Epping to Thornleigh Third Track Proposal. Application number SSI 5132.

I/we object to the Epping to Thornleigh Third Track Proposal and consider that the EIS is inadequate and does not address the full impact of this proposal. It will cause untold damage to the health of residents and to the fabric of the Beecroft Cheltenham Heritage Conservation Area. Do not approve this project, reconsider the alternatives and protect the community.

Figure 5.5 Artist's impression of new elevated concourse at Cheltenham Station looking south from The Crescent (indicated circle)

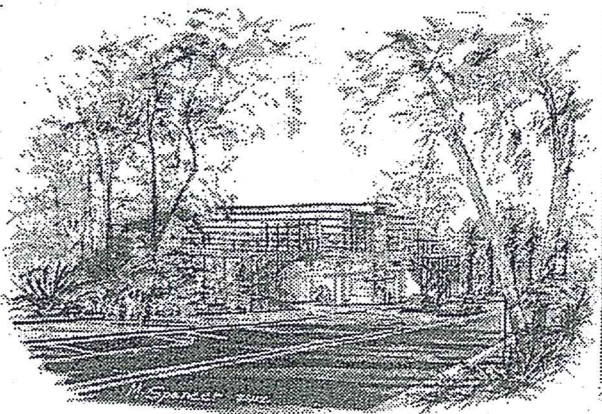
- The proposed redevelopment of Cheltenham Station shows no regard for the HCA. The visual impact of the proposed 13m high glass and steel concourse is totally unacceptable in this HCA.

Concept design drawing of proposed changes to Beecroft Station (Parsons Brinckerhoff 9/3/12). Former side platform shaded in pink.

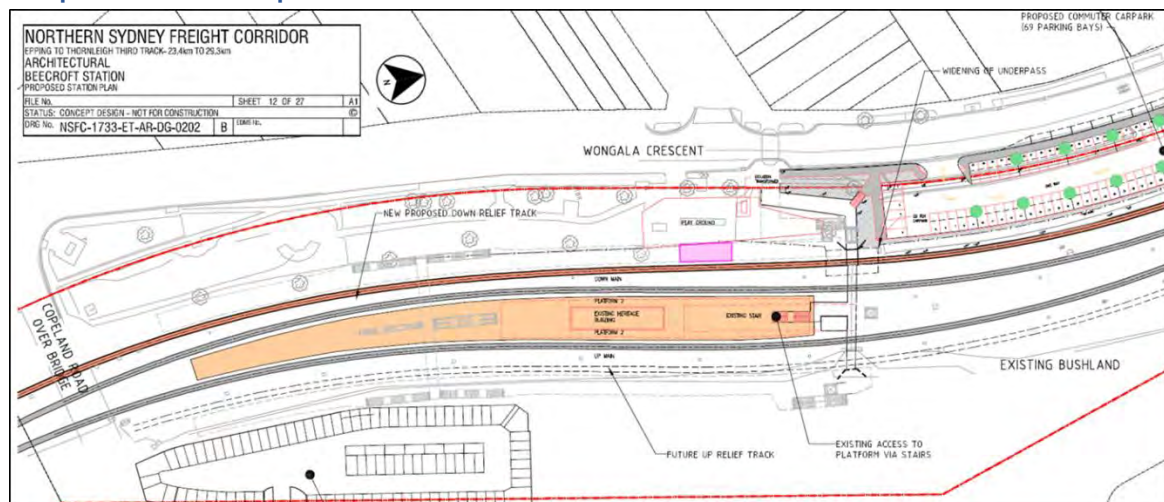
- There has been inadequate assessment of the project's impact on the fabric of the Beecroft Cheltenham Heritage Conservation Area (HCA).
- The plan given for Beecroft Railway station Precinct is vague. The relationship to the trees, playground and original 1895 platform located south of the present station is not shown. A fourth track is shown on the eastern side. The plan does not include urgently needed lifts to allow disabled access at Beecroft Station.

- Beecroft Station Gardens have a heritage listing with Hornsby Council but the impact on them has not been adequately addressed. No arborist's report is given for the trees which will be removed.
